AB/91/12 – Porch to front entrance, conservatory to rear & first floor extension over garage to provide bedroom & bathroom - 11 Dalloway Road Arundel BN18 9HJ

I act for Mr and Mrs. Gibbons of 13 Dalloway Road in this matter who **wish to register their objection** to these proposals for the following reasons:

PROPOSED FIRST FLOOR PLAN

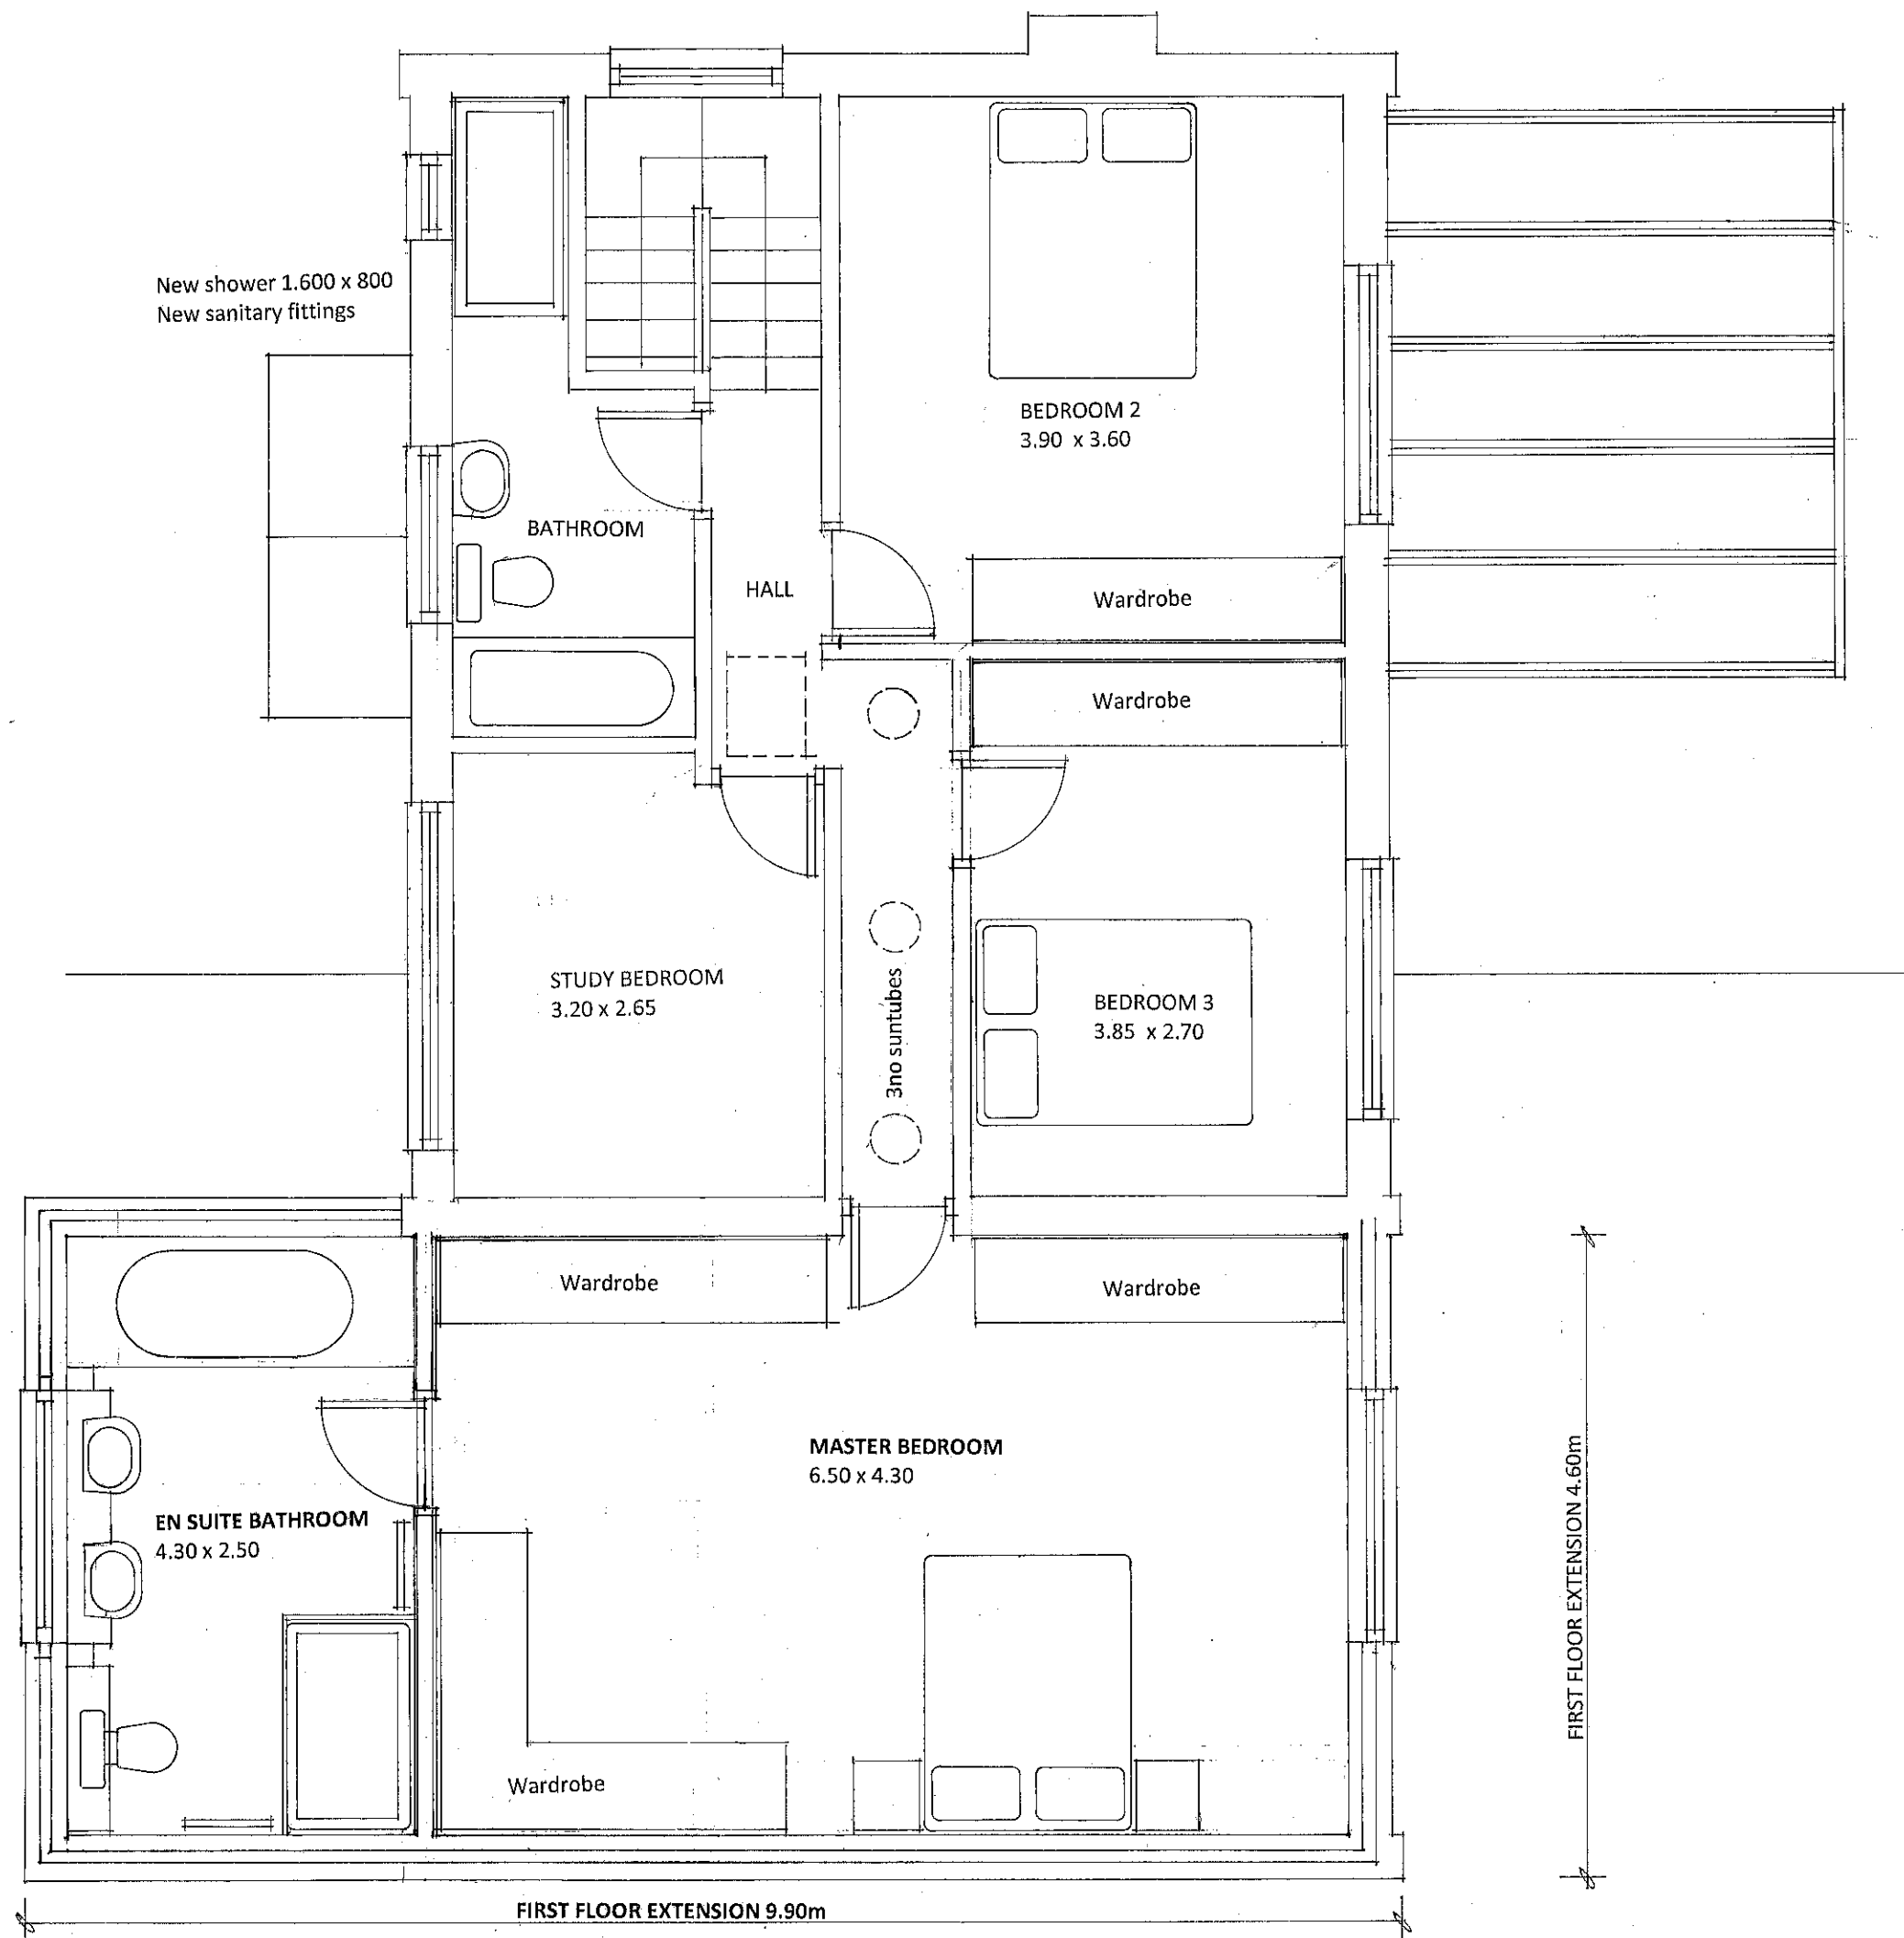
The proposed extension would extend the full length/depth of the existing single storey garage which forms the joint boundary and would result in an

uncharacteristic two storey extension jutting forward towards the road and a two storey end gable wall on the line of the existing boundary resulting in a closing of the visually important and characteristic gap at first floor level between the properties.

The proposed extension would result in a towering two storey gable end wall running the full length of the existing garage flank wall in close proximity to these windows and rear patio area which would deprive the rear windows of that early morning sunlight and be visually dominating. The overall effect would be a two storey extension that would be unduly overbearing and oppressive when viewed from these windows and the rear patio area.
